From: Laura Gibbons
Sent: 30 November 2018 16:14
To: Planning.Responses
Cc: Michael Eastham
Subject: RE: Planning Consultation on: WA/95/18/RES

Engineers Informative Comments Regarding Surface Water Drainage

APPLICATION **WA/95/18/RES**

Site Address: Land east of Tye Lane Walberton

TYPICAL CELLULAR SOAKAWAY DETAIL
(1:20)

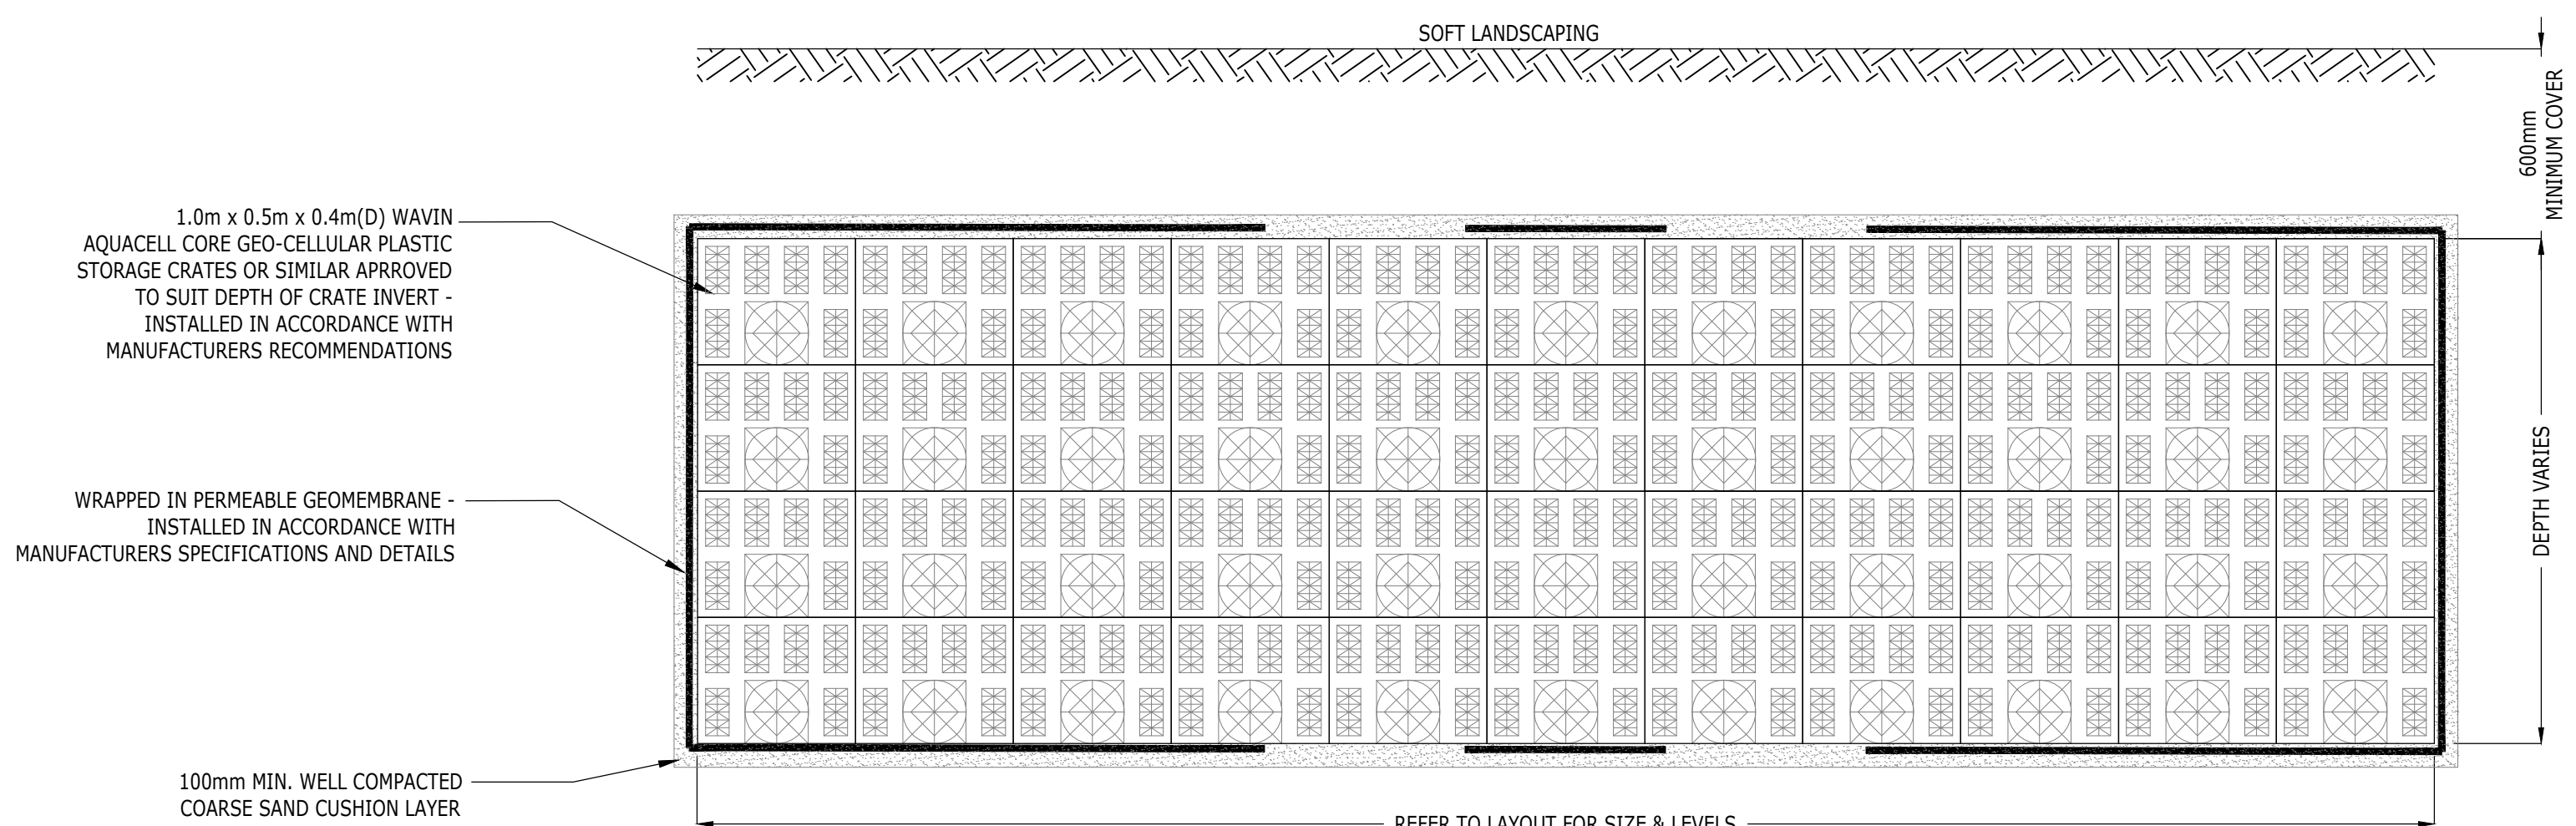
- Groundwater monitoring results and infiltration test results, including depths of testing.
- Location plan showing monitoring and testing locations.
- Full calculations demonstrating that the 1 in 100 year plus 40% climate change event can be accommodated.
- Calculations detailing that minimum half drain time requirements are met.
- Safety factors are applied to design in line with CIRIA requirements. i.e.

Size of Area to be Drained	Consequences of failure					
	No damage or inconvenience		Minor inconvenience, e.g. surface water on car park		Damage to buildings or structures or roads.	
	Cv=1.0	Cv=0.75	Cv=1.0	Cv=0.75	Cv=1.0	Cv=0.75
<100 m ²	1.5	2	2	3	10	13
100m ² to 1000m ²	1.5	2	3	4	10	13
>1000m ²	1.5	2	5	6.5	10	13

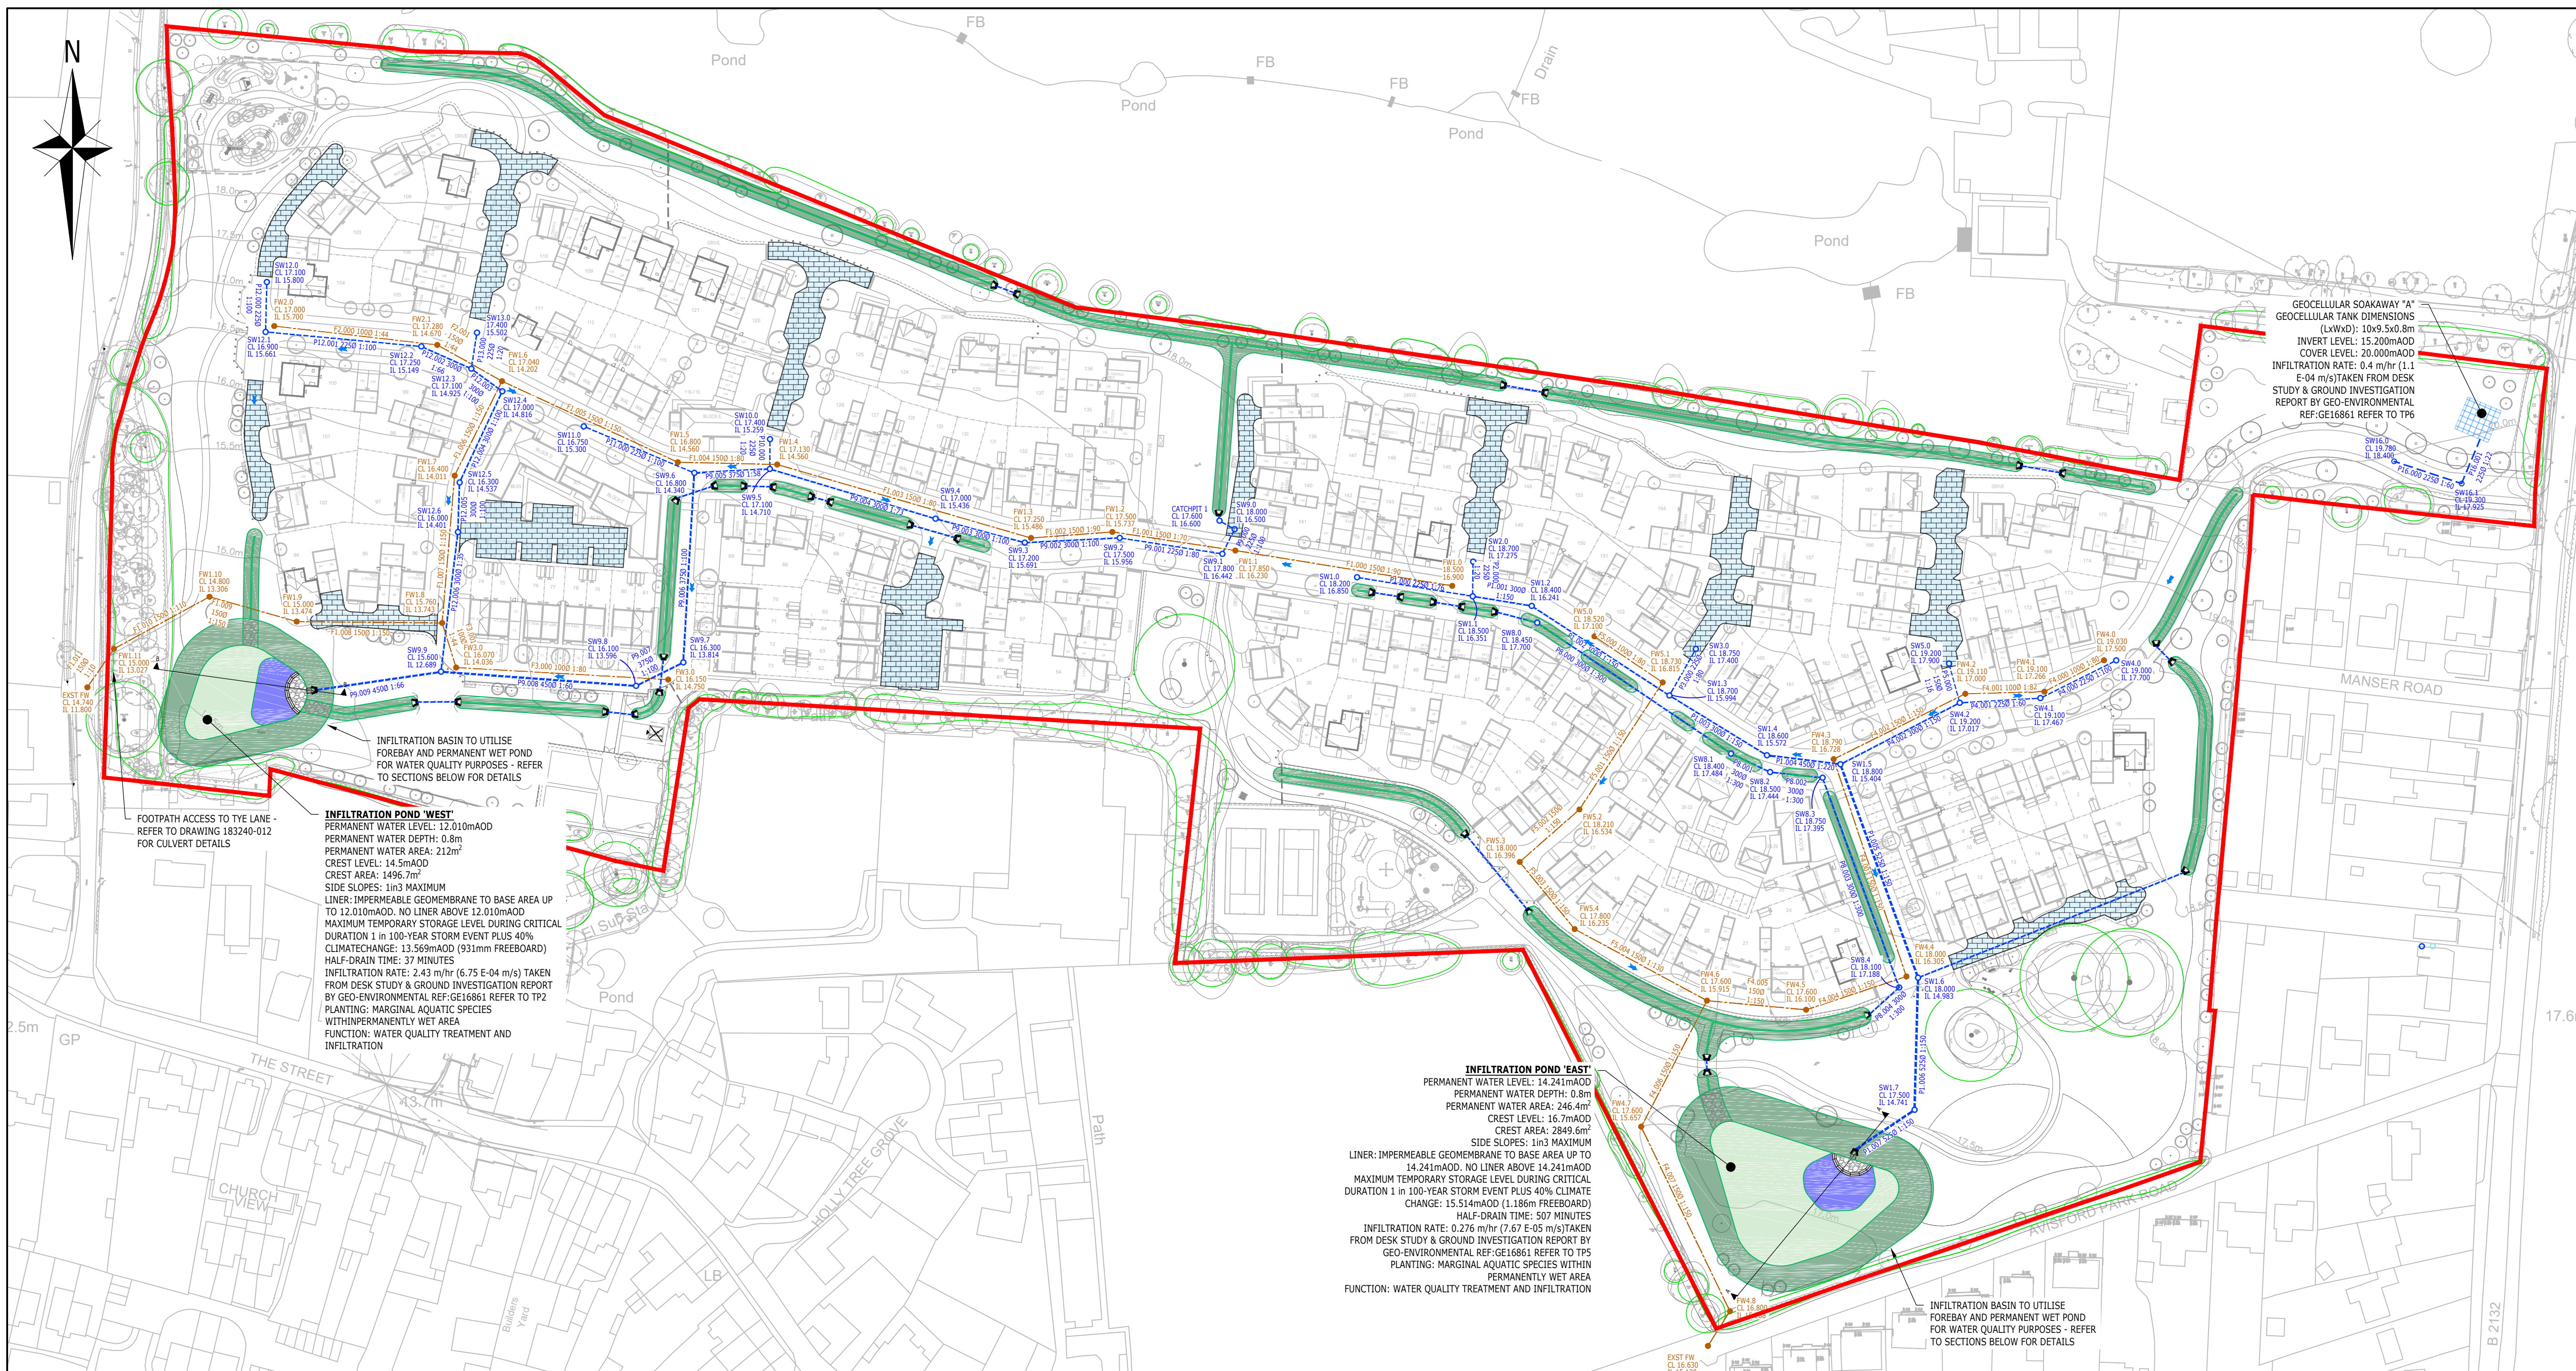
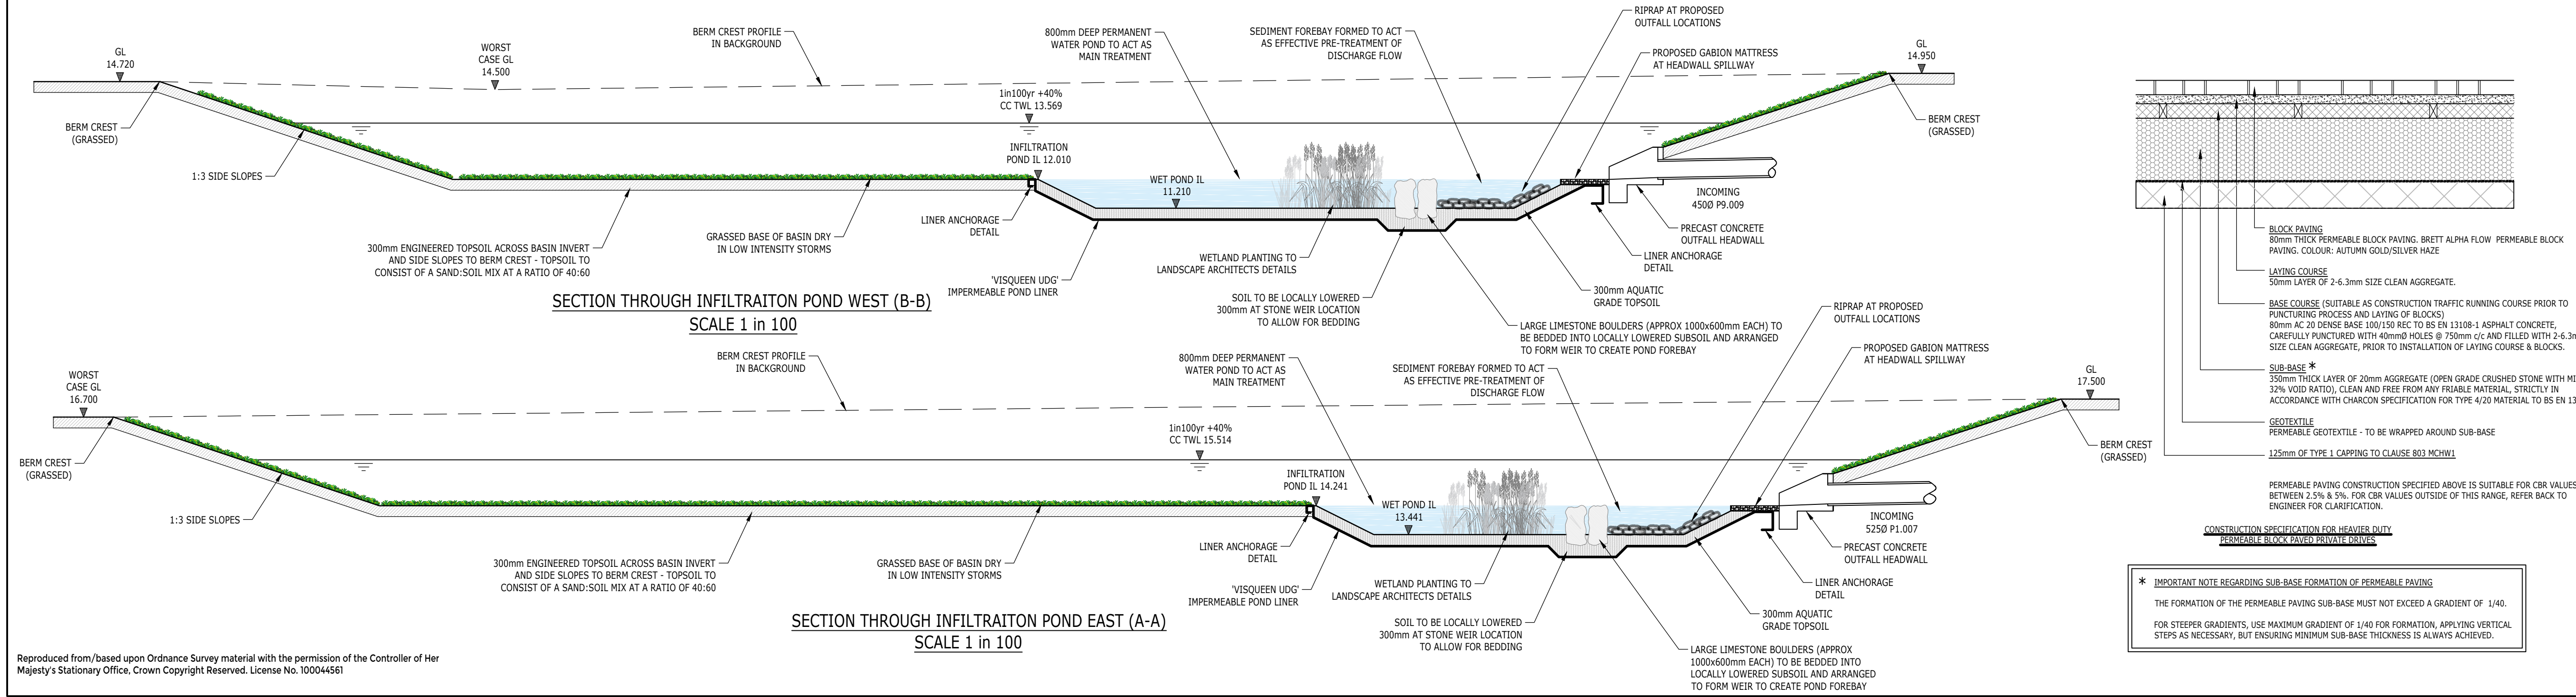
- Drainage layout plans, to include:
 - All surface water drainage pipes labelled with; diameters, falls and invert levels.
 - All infiltrating and attenuating structures (including permeable paving) labelled with; dimensions, invert and cover levels.
 - All manholes labelled with; cover levels, invert levels, cover types detailed.
 - All silt traps clearly labelled with sump depths.
 - Control structures with outflow rates and invert levels.
- Construction detail drawings, to include (if specified in scheme): pipe bed and surround;
 - infiltrating structures;
 - attenuating structures;
 - manholes;
 - catchpits/silt traps;

- control devices;
- permeable paving;
- headwalls.
- * Exceedance flow routes
